DEVIATION REQUEST AND DECISION FORM

Project Name : **BENT GRASS EAST COMMERCIAL FILING NO. 3**
 Schedule No.(s) : 53011-01-060
 Legal Description : Tract BB, Bent Grass East Commercial Filing No. 2B

BENT GRASS MARKET VIEW

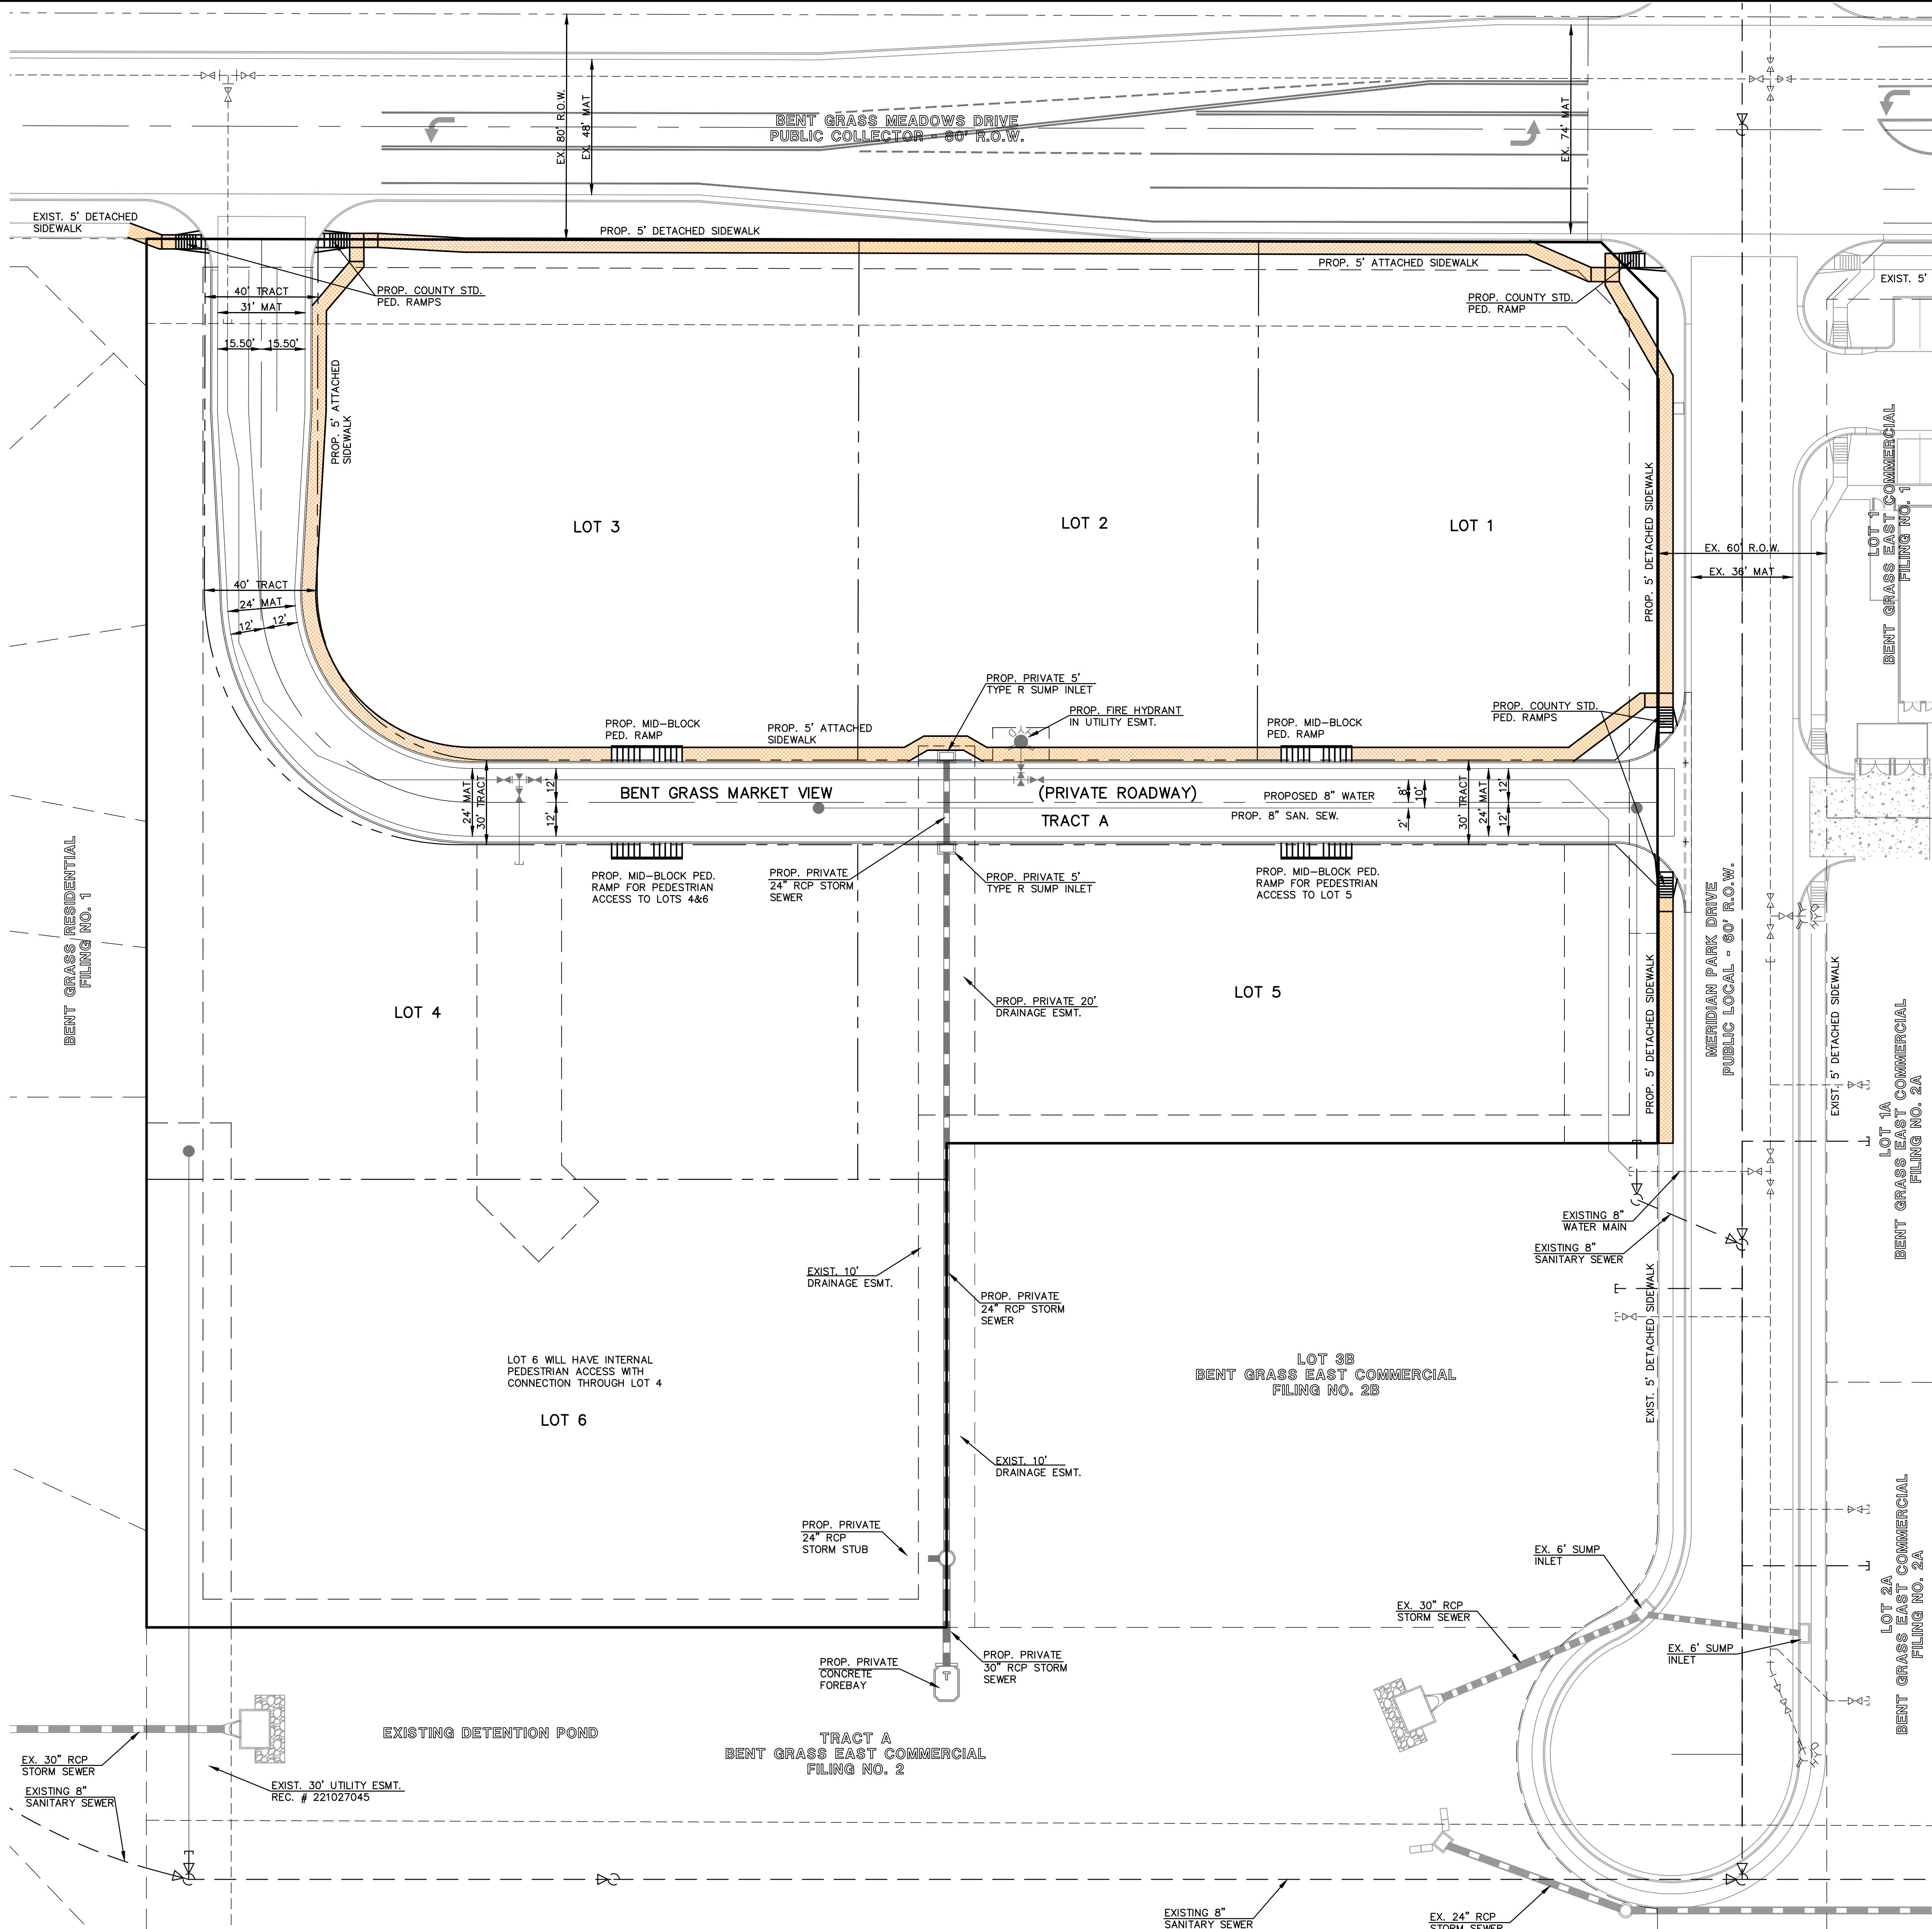
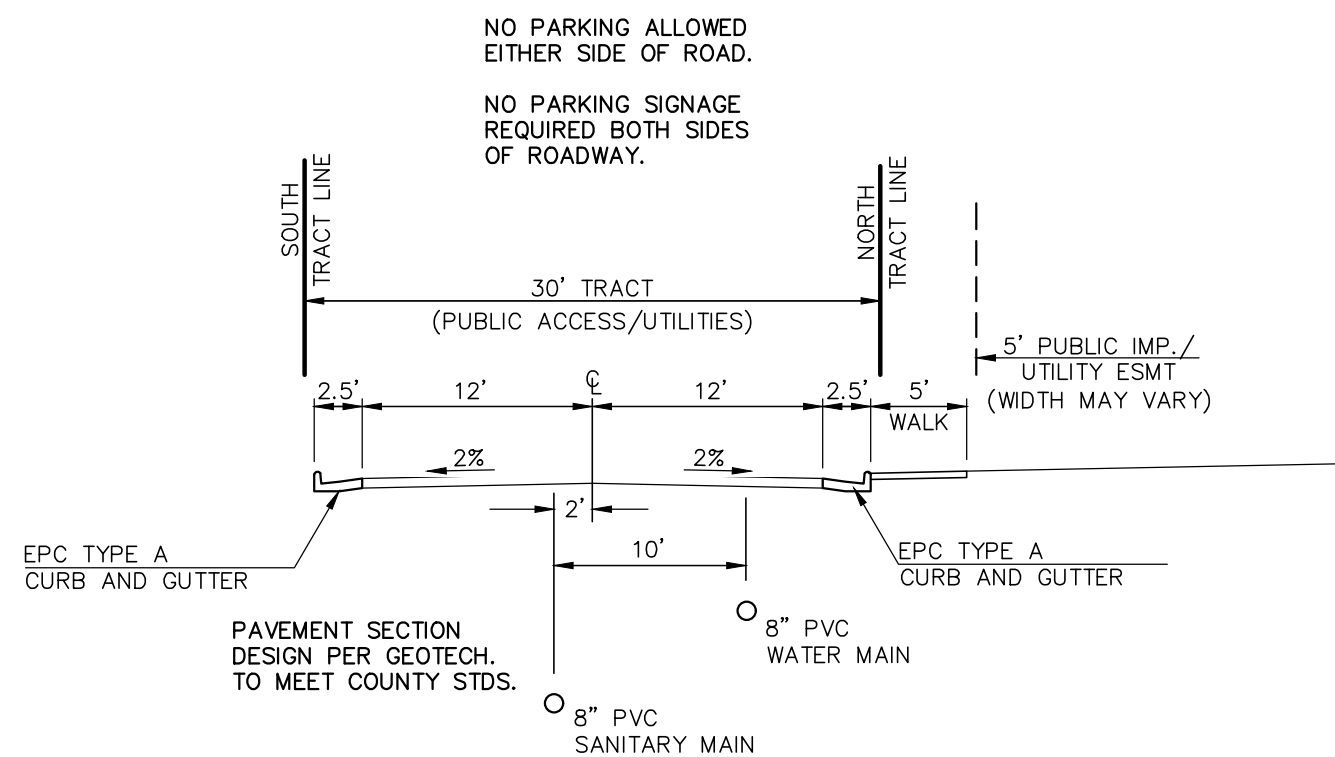
Please provide an exhibit of the proposed roadway

Please provide further justification for the proposed alternatives to the ECM standards. How is the proposed road section adequate for the traffic that is generated by the site, especially the truck traffic? indicate how the proposed radius of the roadway is adequate? Additionally please provide justification for the lack of the sidewalk on the south side of the proposed roadway. Based on the proposed land uses in the TIS (Fast food, business park, and shopping center) it appears that pedestrian access by means of a sidewalk and midblock crossing would be needed and beneficial to the development to access the southerly lots.

N:\217764\DRAWINGS\truck turning.dwg, 5/4/2021 4:50:26 PM, 1:50

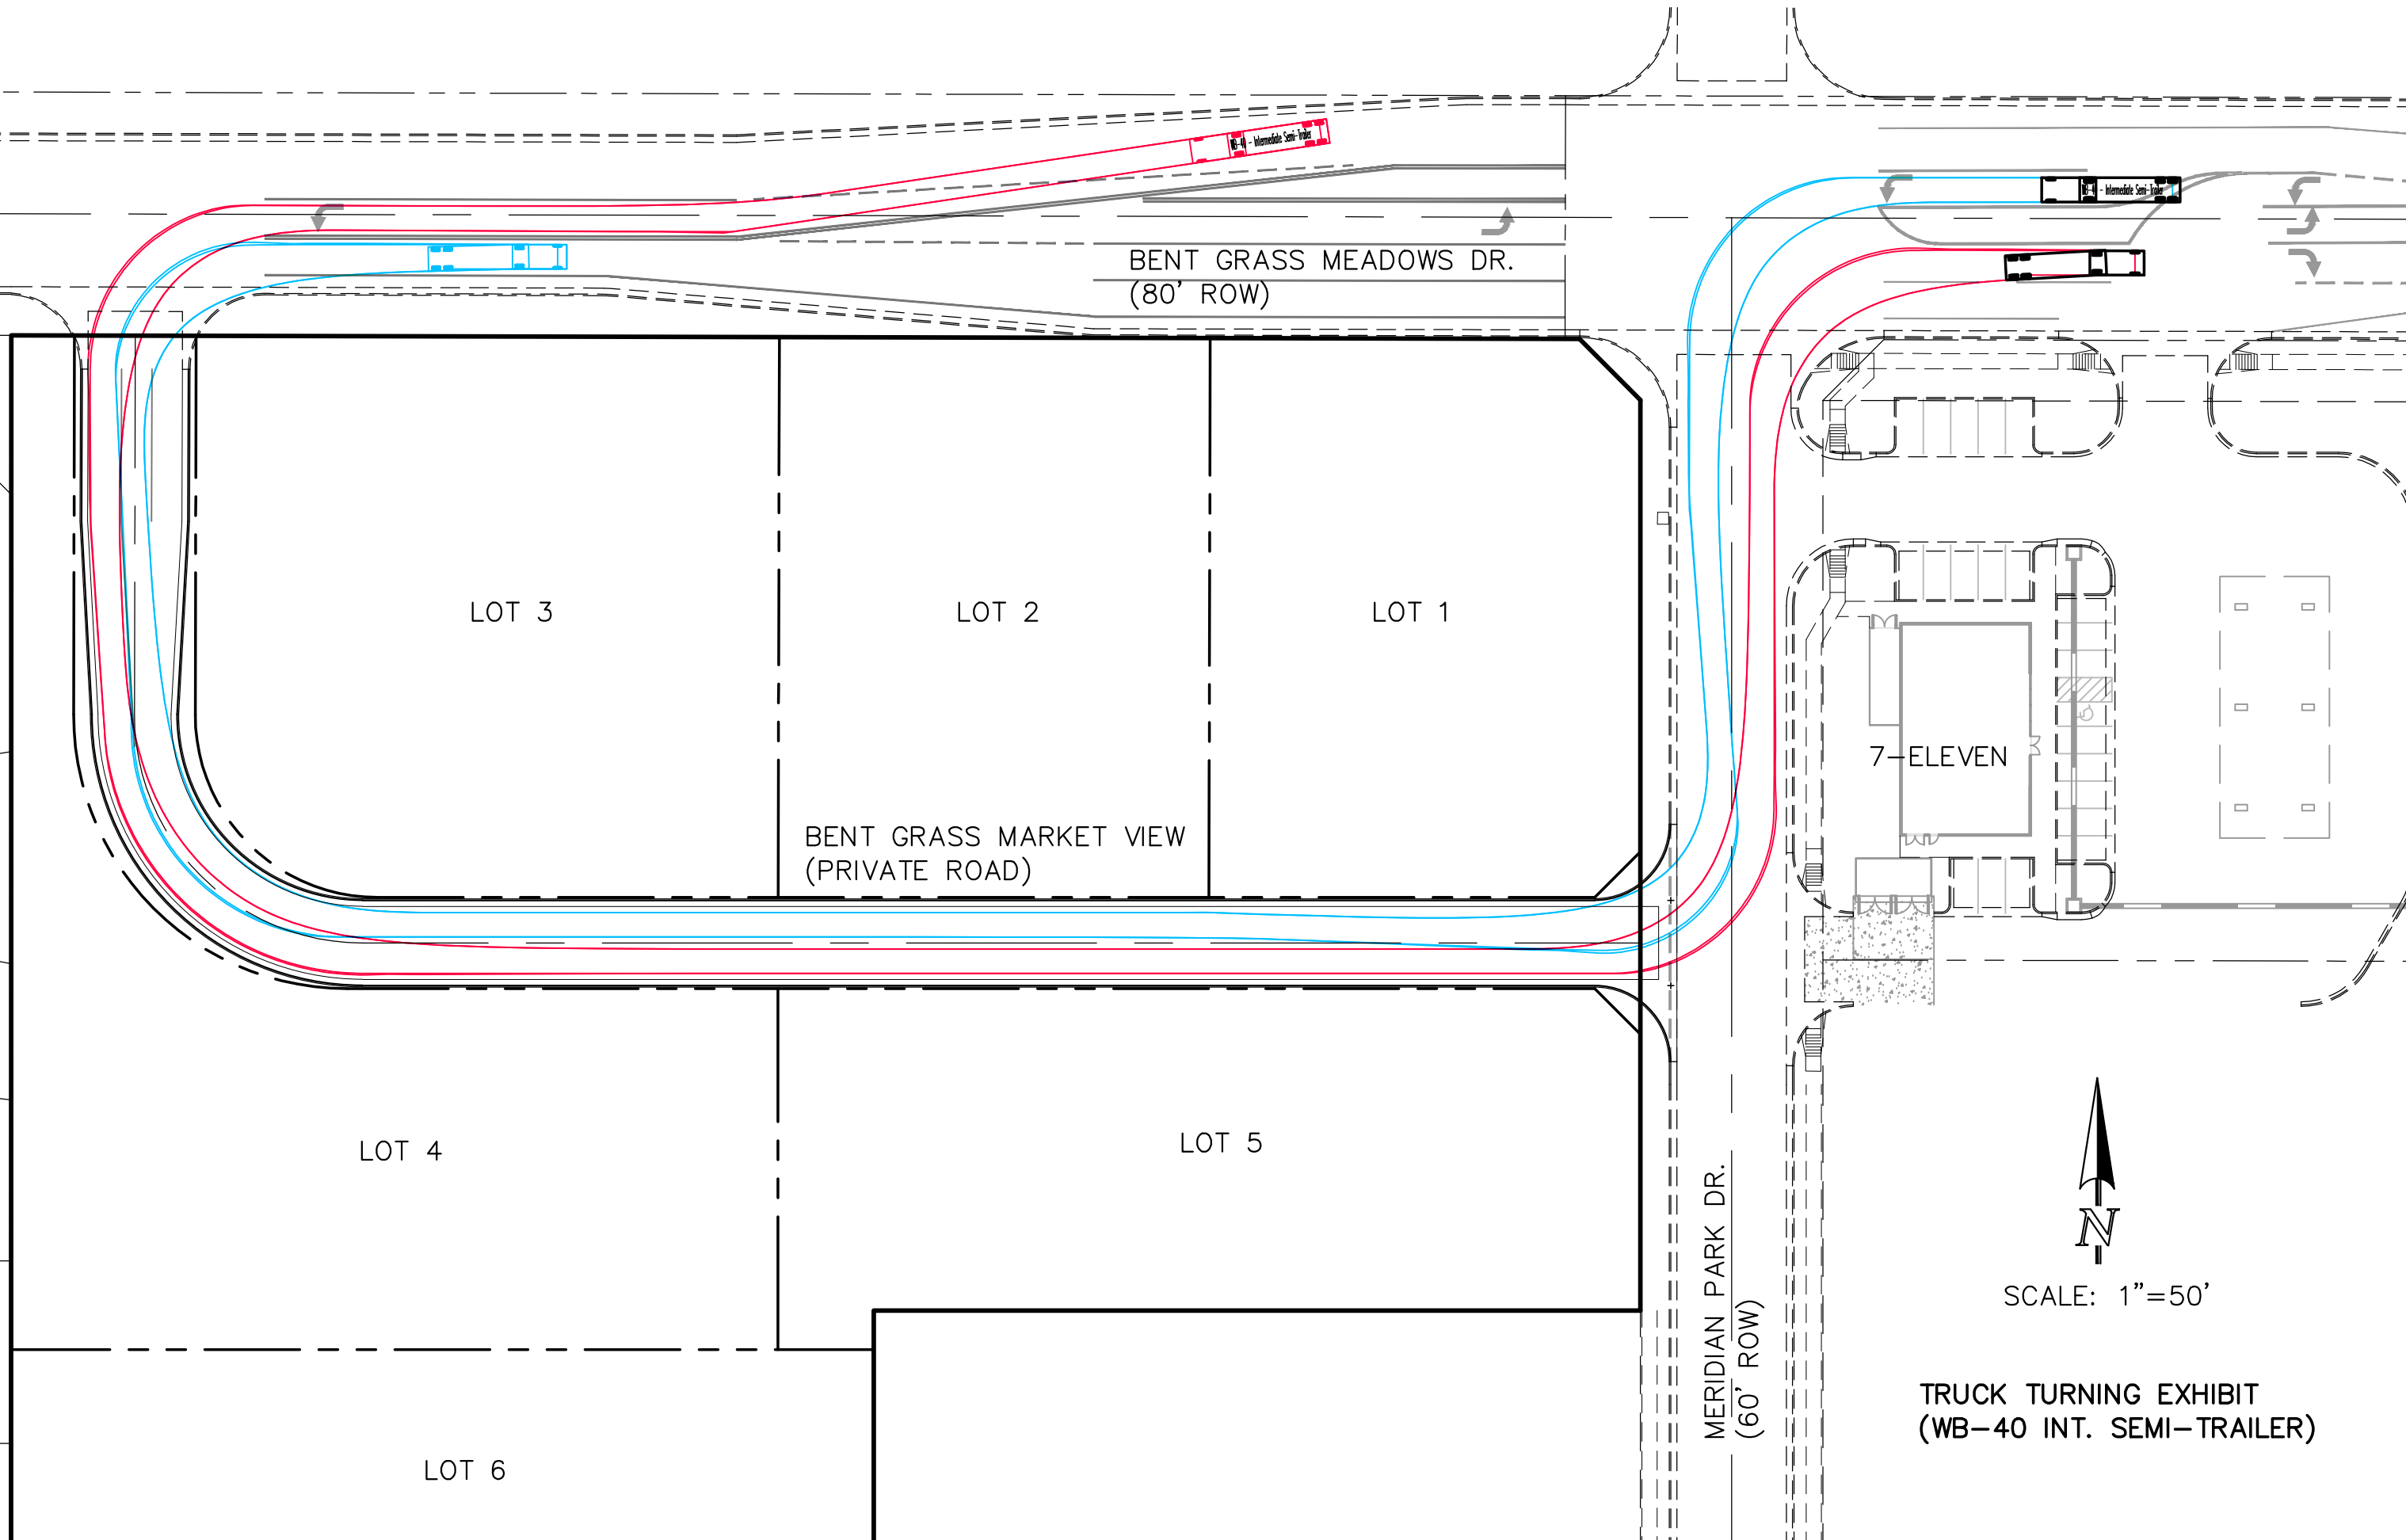
Per ECM 2-36 the design vehicle for commercial/retail land uses are multi-unit trucks. Provide an auto-turn exhibit with the appropriate design vehicle for this roadway to ensure that the radius proposed is sufficient.
